DEVELOPMENT REVIEW BOARD
TRANSPORTATION DEVELOPMENT

DRB Project Number: 1004908
Keeran & Oakland

SUBJECT: Preliminary/ Final Plat

Application #: 18DRB-70082

PLAT OF LOT 5-A-P1 ESTRADA COURT SUBDIVISION AND LOT 1-A KELLER LANE SUBDIVISION SITUATE WITHIN PROJECTED SECTION 17 T.11N., R.4E., N.M.P.M. ELENA GALLEGOS LAND GRANT CITY OF ALBUQUERQUE BERNALILLO COUNTY, NEW MEXICO MARCH 2018

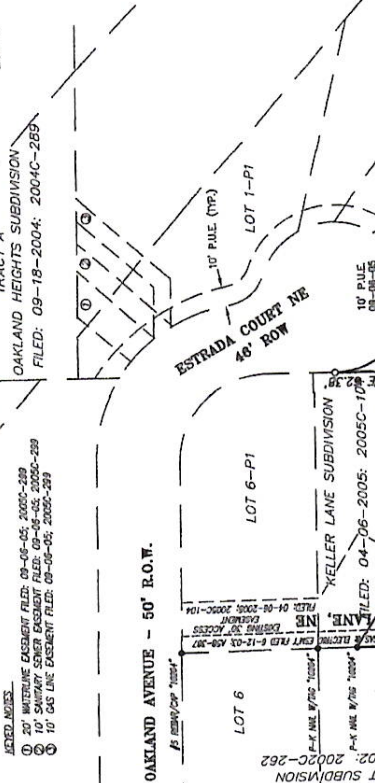
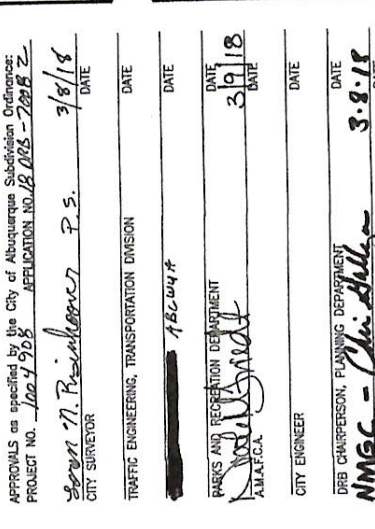
1. Please provide the existing access easement showing with all beneficiaries and maintenance responsibilities.
2. Provide a sidewalk exhibit showing the location, width, and defining the distance from back of curb to the property line. Right of way dedication may be required.

-
- Zoning is RD – 3/DUA. Application just states 3 DU.
 - New plat has a signature lien for Qwest which should be revised for Comcast.
 - No Adverse comments. Planning will need delegation to ensure all the required signatures are on the plat.
